**Consultation Response from KC,  
Highways Development Management**

**2024/93394 land between, Bradshaw Road and Honey Head Lane, Honley, Holmfirth, HD9 6EE**

**Discharge of details reserved by conditions 3 (access and parking provision), 4 (parking and visitor parking), 5 (turning facilities), 6 (construction traffic), 7 (collection of wastes), 11 (external materials), 12 (boundary treatments) on previous 2024/90616 permission for erection of two detached dwellings**

**Date Responded: 11/12/2024**

| PAPER SIZE<br><b>A2</b>                              | DWG NUMBER<br><b>(70)002</b> | DATE<br><b>15/11/23</b> | REVISION<br><b>/</b>                   |

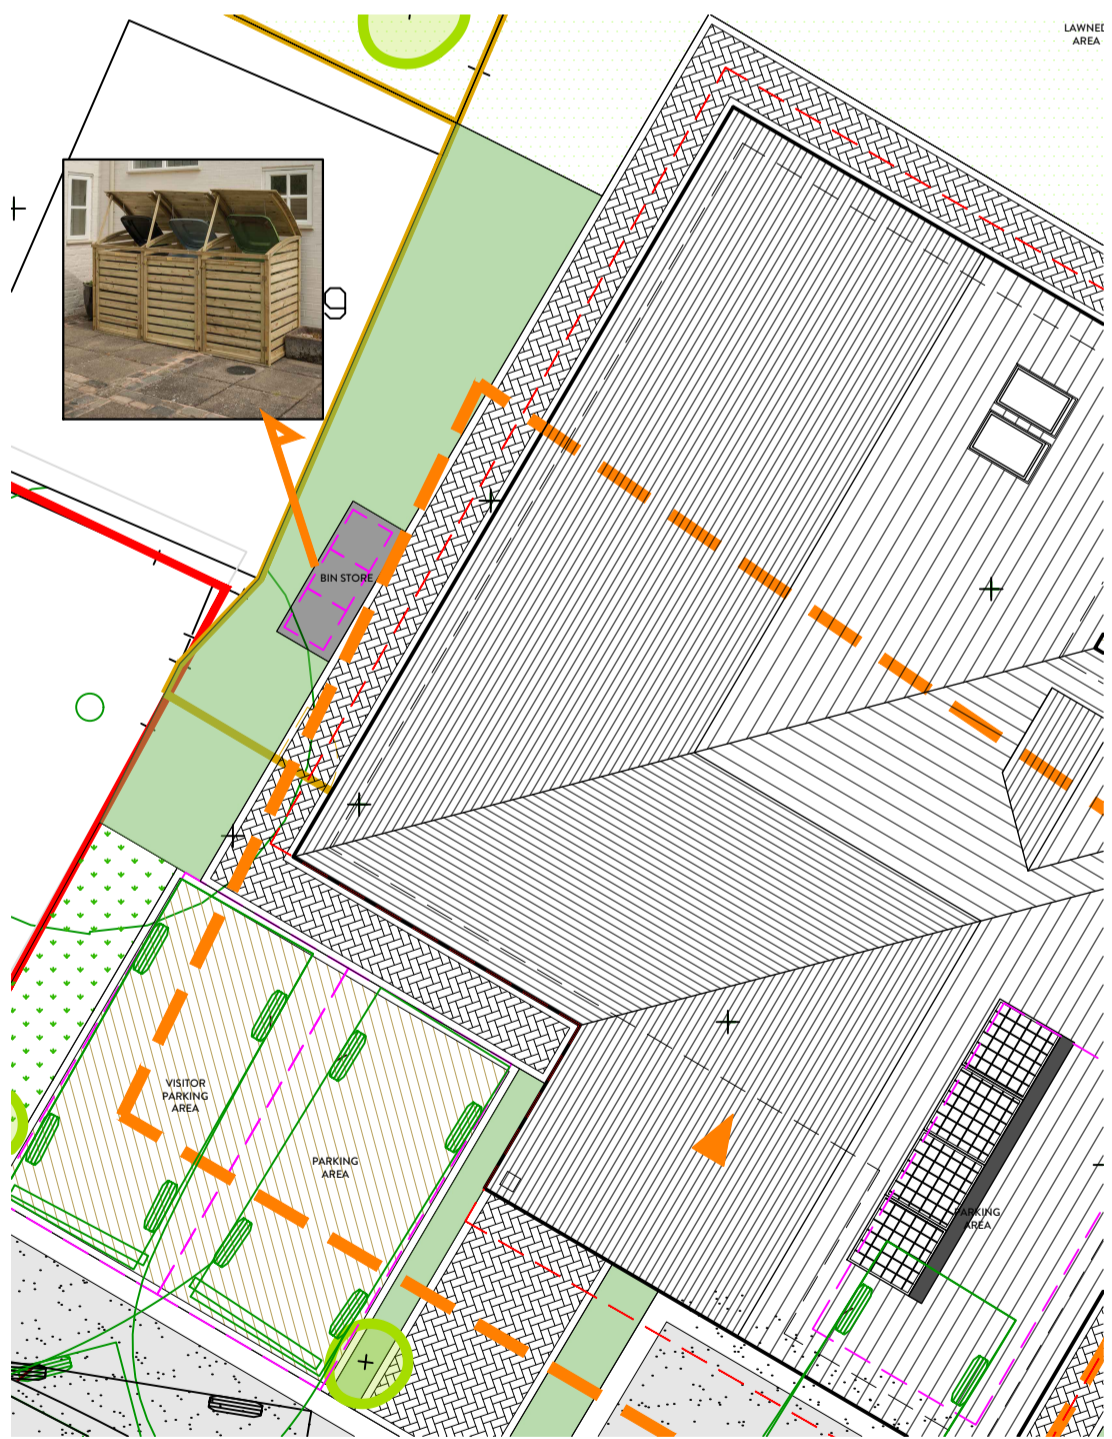
The information provided for the waste storage and collection points as shown on drawing No (70)002 are acceptable for the discharge of condition 7. However it should be noted that the bin storage and presentation points for plot 1 are separated by the car parking area and this may cause problems for the occupier on collection day if cars are parked in both spaces and the bins are required to be moved.
